COMMUNITY DEVELOPMENT DEPARTMENT
501 Delta Avenue ♦ Marysville, WA 98270 ♦ (360) 363-8000

Re: PA22-033, E. Sunnyside PRD, *Technical Review 2*
4617 87th Ave NE – APN(s) 00590700016201 / 00590700016202

NATURAL 9 HOLDINGS, LLC
E SUNNYSIDE PRD
PERLIMINARY GRADING PLAN

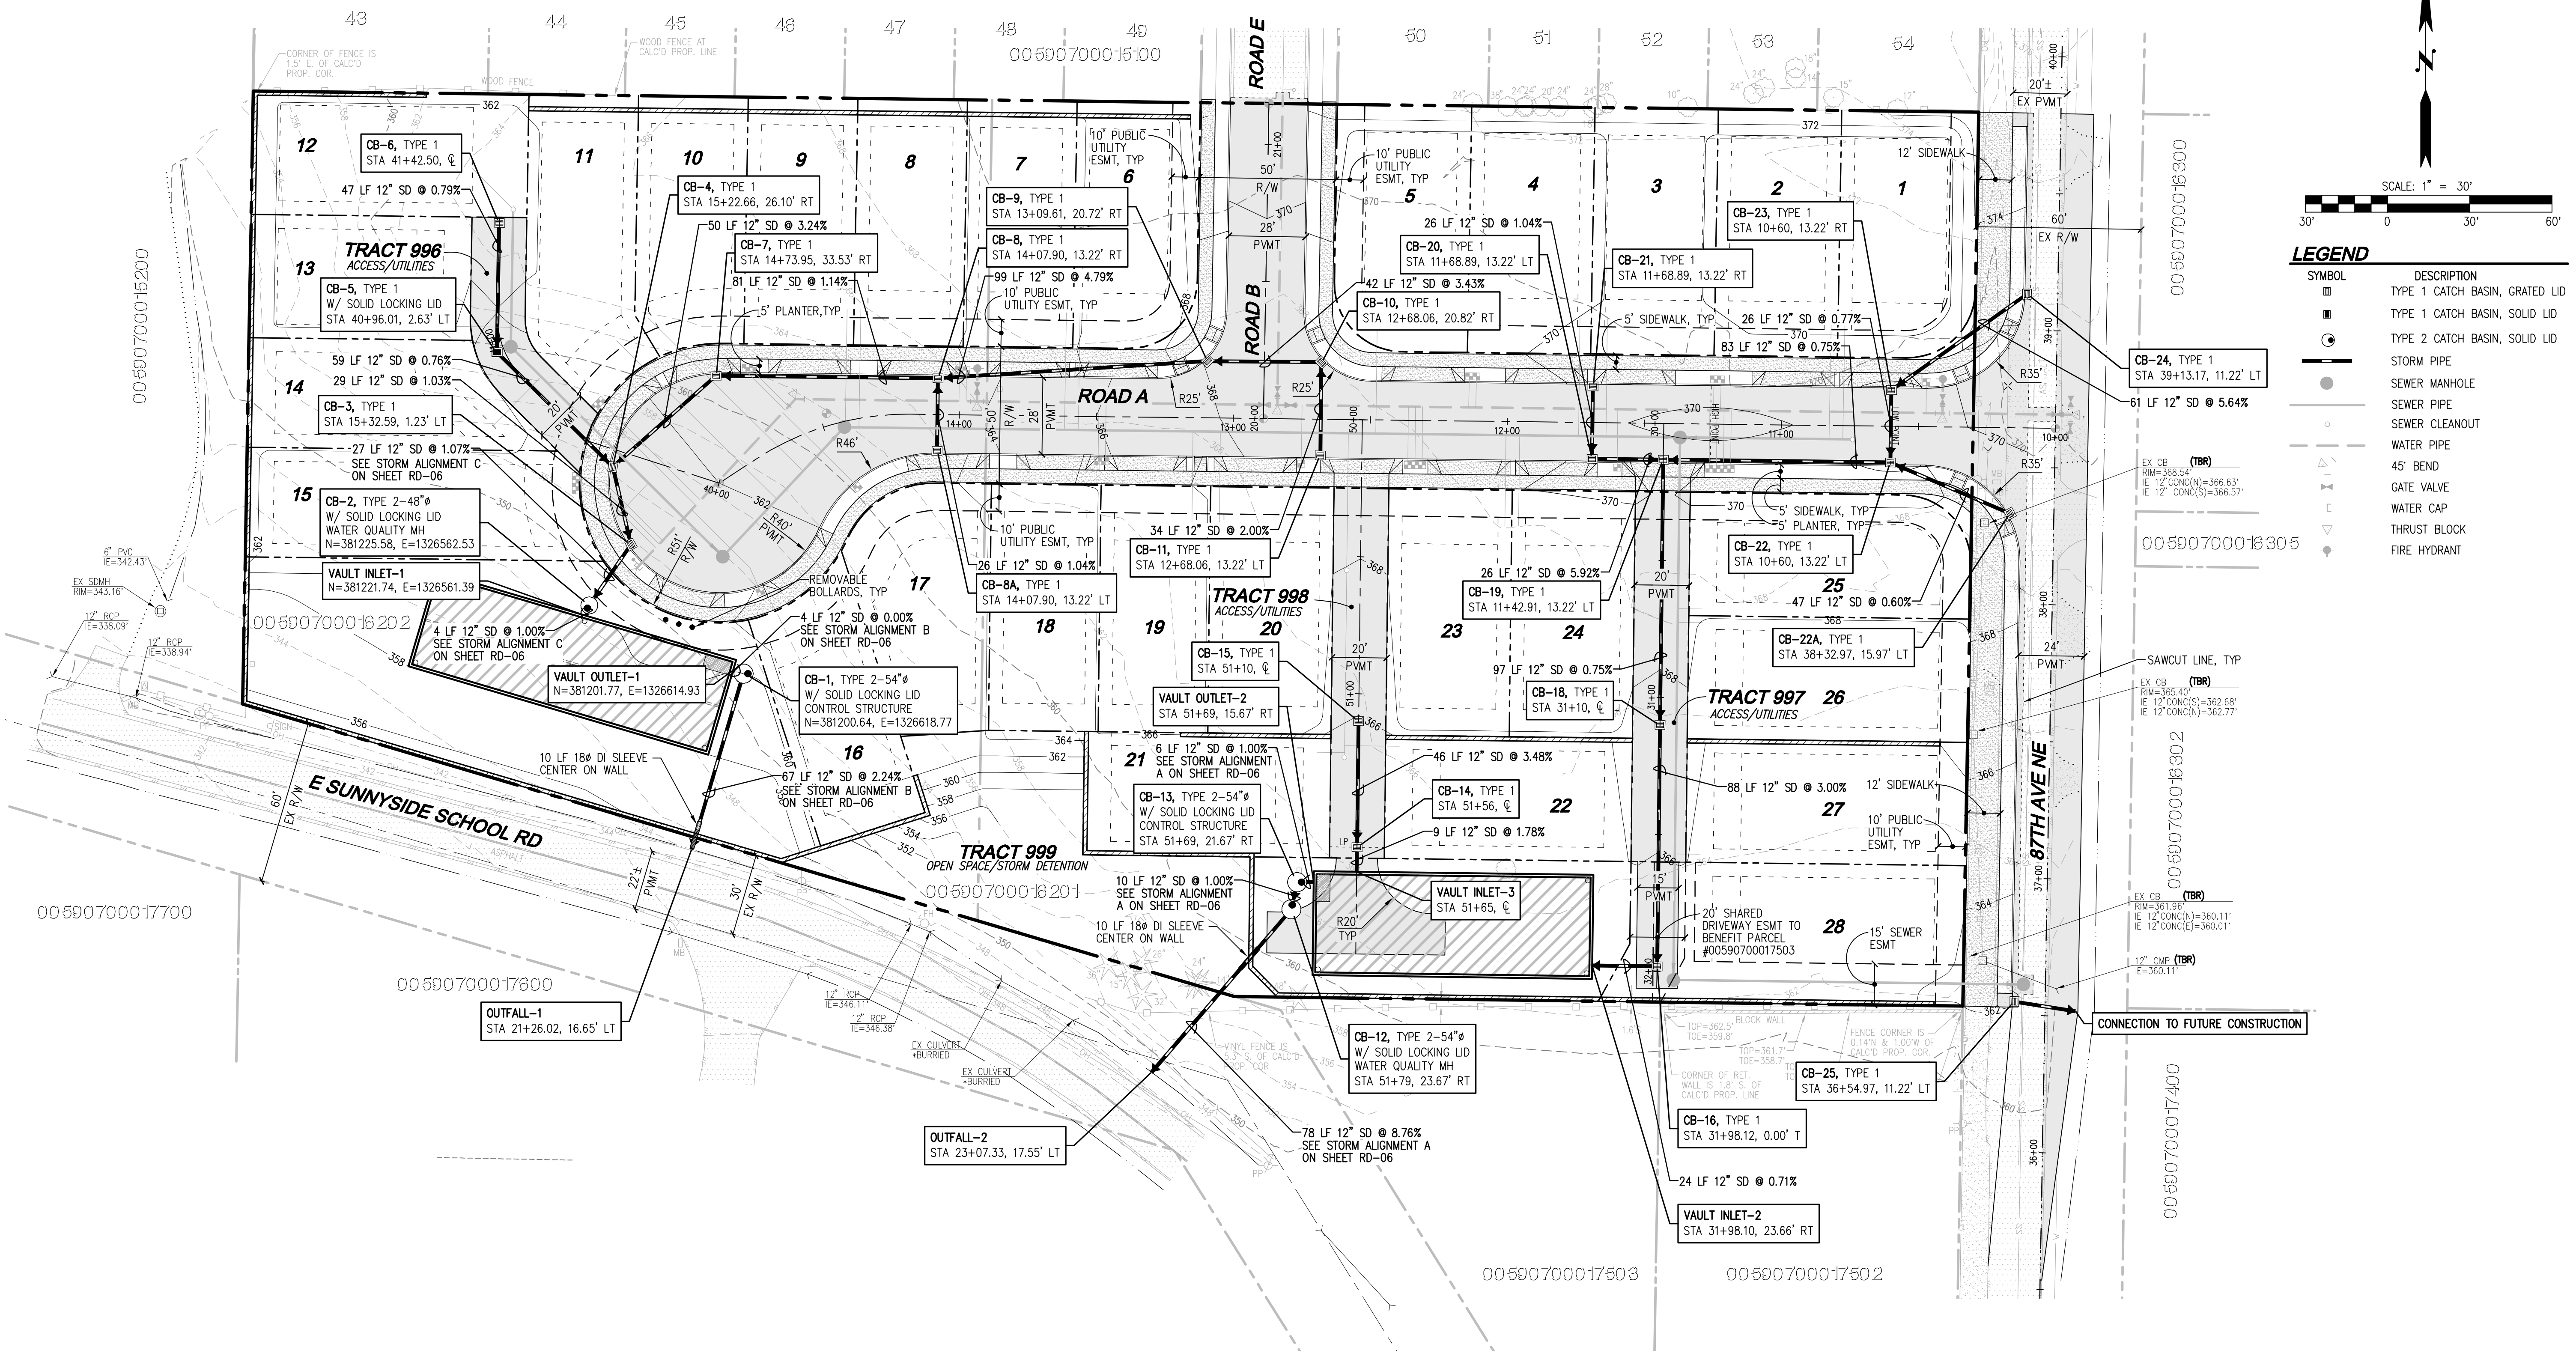
1. Modify the proposed grades so that the development can follow the natural topography of the site to the maximum extent feasible ([MMC 22D.050.030\(4\)](#)). Eliminate, or reduce the height of the terraced retaining walls along Tract 999.

2. Modify the proposed modification of Lots 8-16 to eliminate the need for or reduce the height of the proposed retaining wall. Suitable house plans may propose basement (tuck-under) garages to fit the natural topography.

3. Modify the grades for Lots 19 – 21, eliminating the proposed walls and follow the natural topography of the site to the maximum extent feasible.
4. With the grade changes, ensure that at least 35% of the open space is active open space per [MMC 22G.080.100\(4\)](#).

87TH AVE NE ROAD SECTION
SCALE: 1"=5'

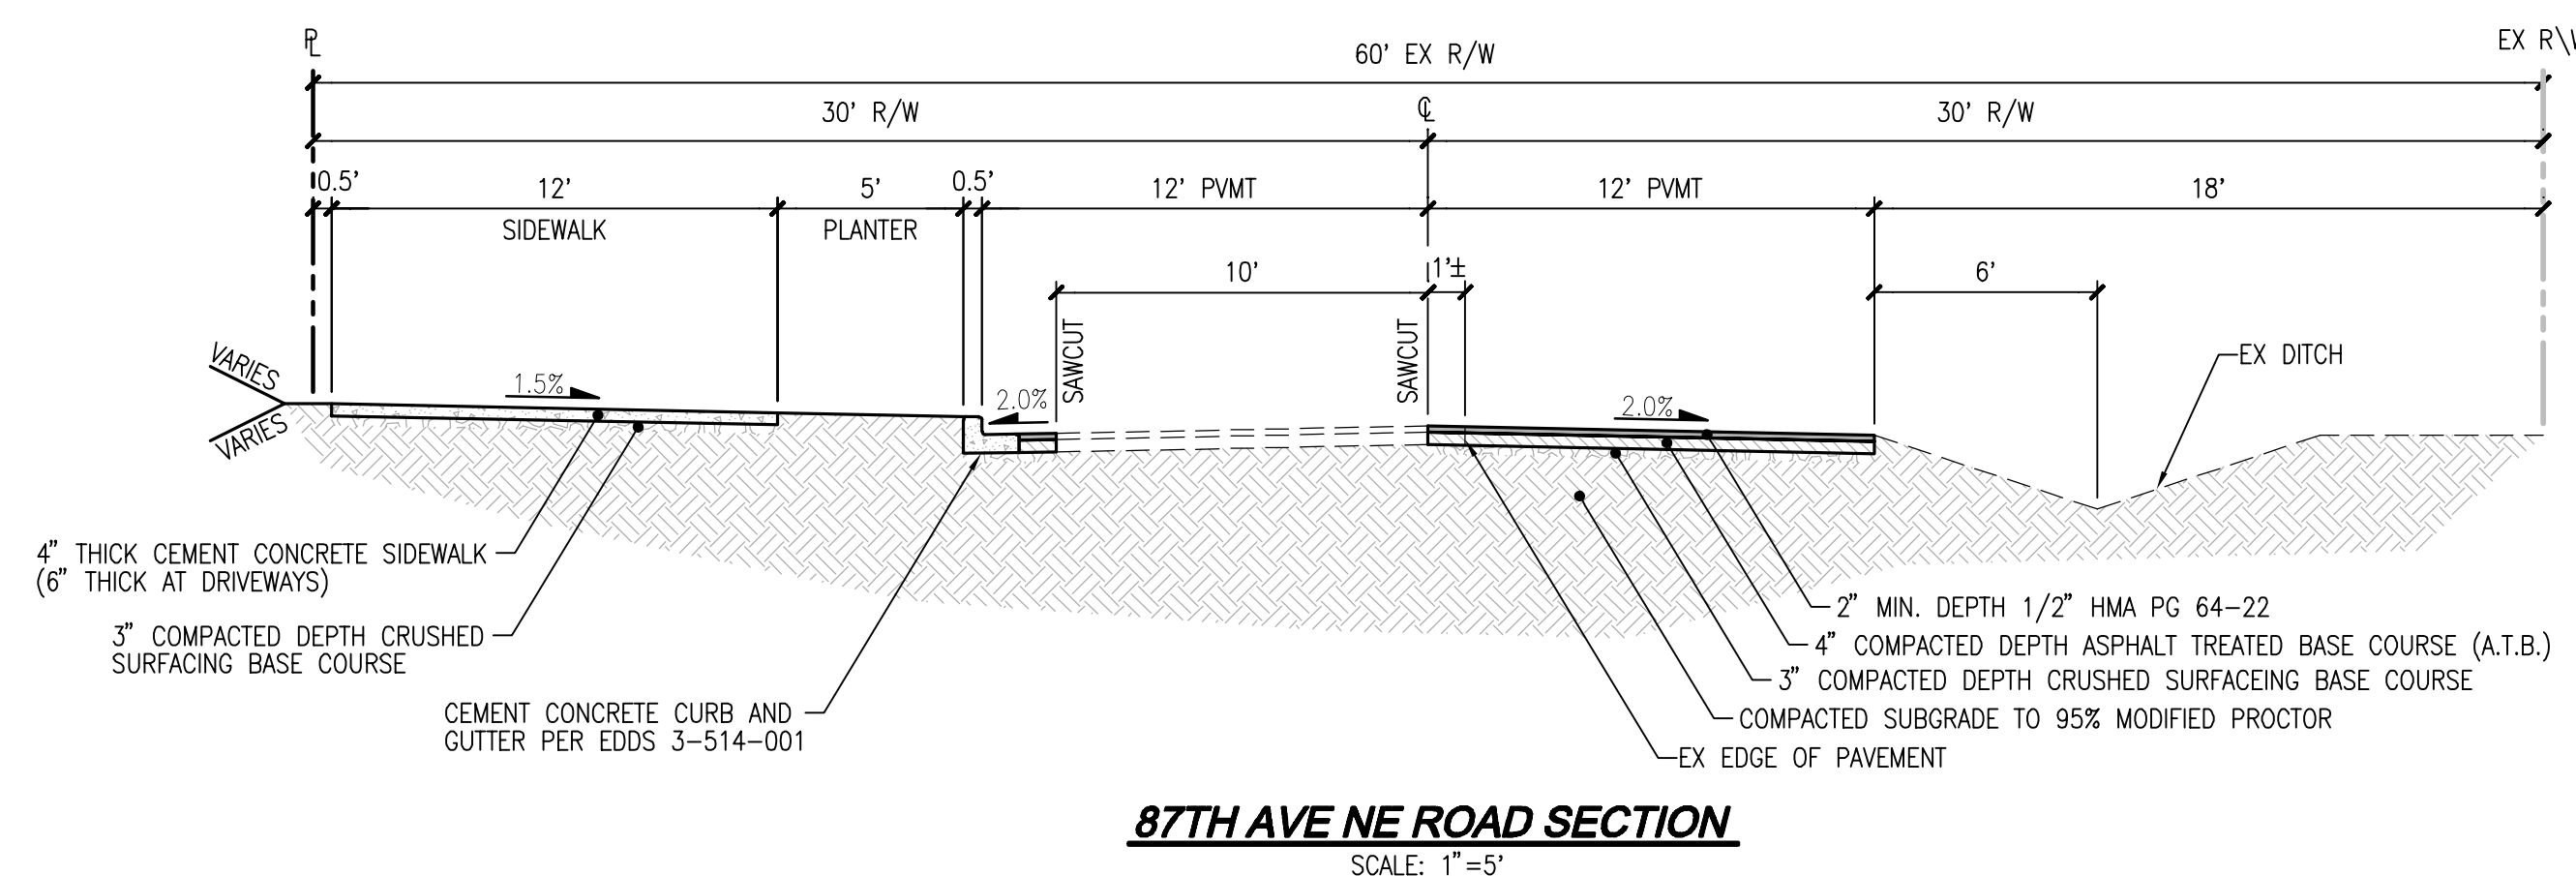
- 1) Undergrounding of overhead utilities along frontage shall be required.
- 2) 87th Ave NE frontage:
 - a. Designated as Collector Arterial roadway with 22' of asphalt pavement including curb, gutter, 12' multi-use trail, landscape strip and city owned decorative street lighting.

- b. Frontage shall be constructed per EDDS Standard Plan 3-201-008 within 60' ROW.
- 3) Per EDDS 3-506, street lighting will be required.
 - a. Street Lighting upon residential street(s) shall be PUD installed fiberglass pole installation type street lighting.

NATURAL 9 HOLDINGS, LLC  
**E SUNNYSIDE PRD**  
 COVER SHEET

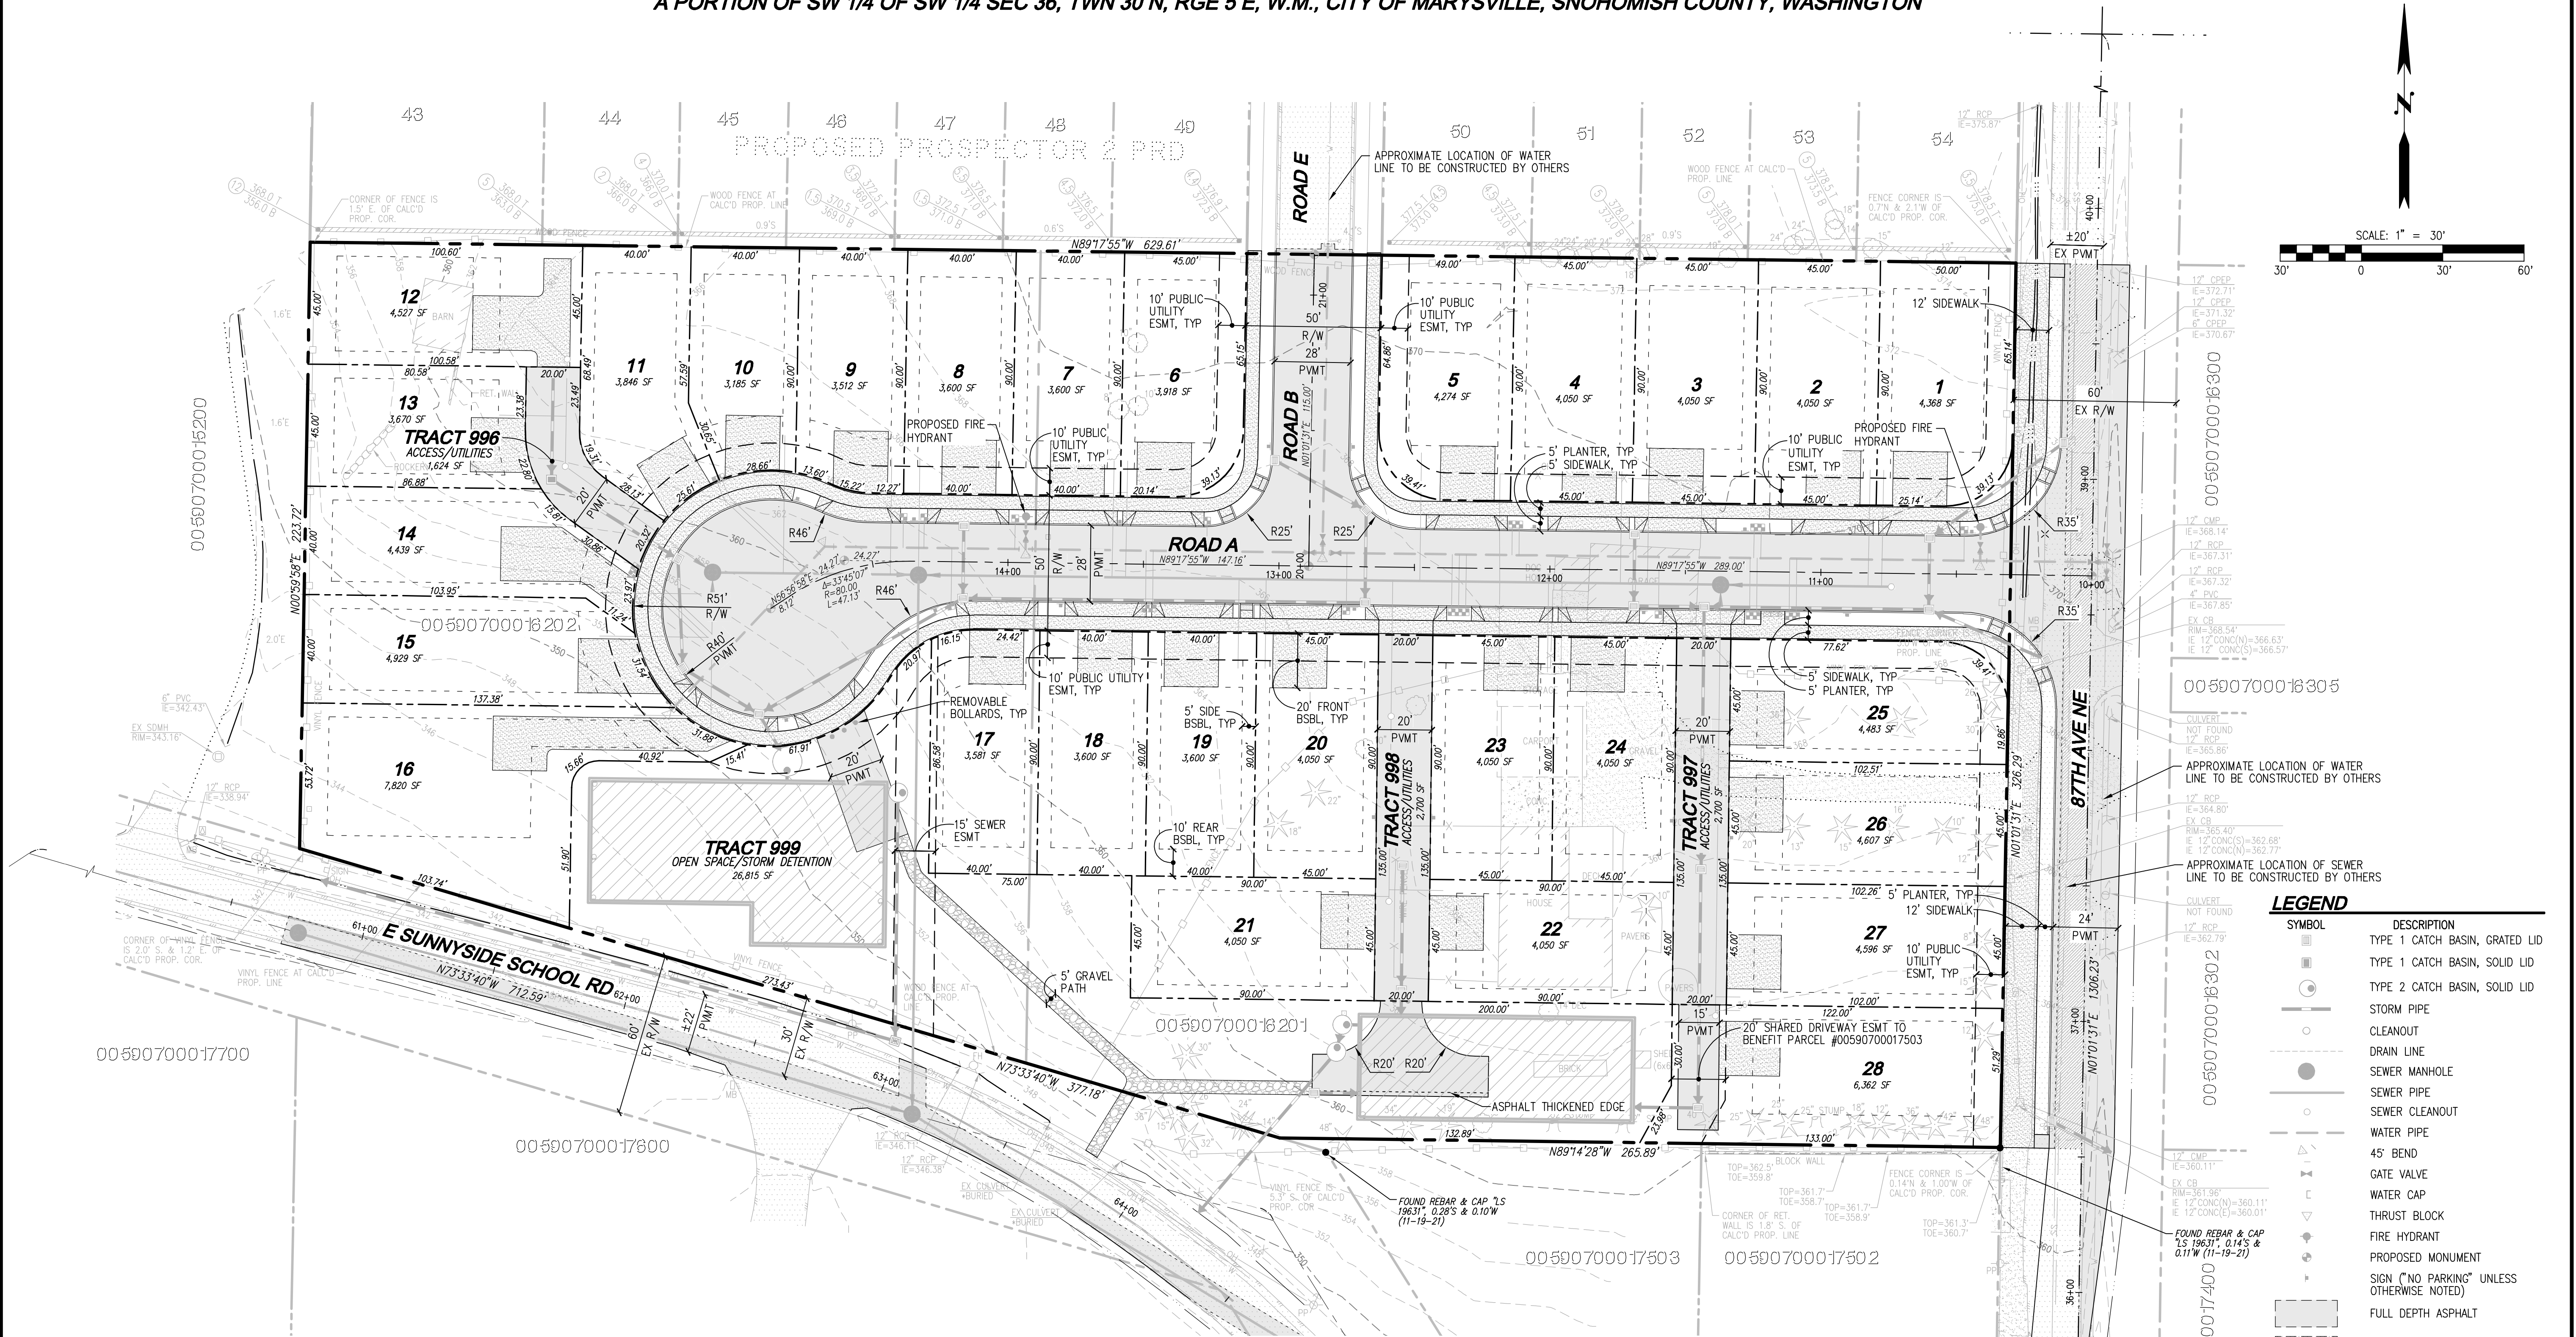
11. In the title, replace “Plat” with “Binding Site Plan”.
12. Tracts 996, 997, and 998 are required to be surfaced with scored concrete, paving blocks, bricks, or other ornamental pavers to clearly indicate that the entire surface is intended for pedestrians as well as vehicles. Update the preliminary civil and landscape plans to reflect this change.
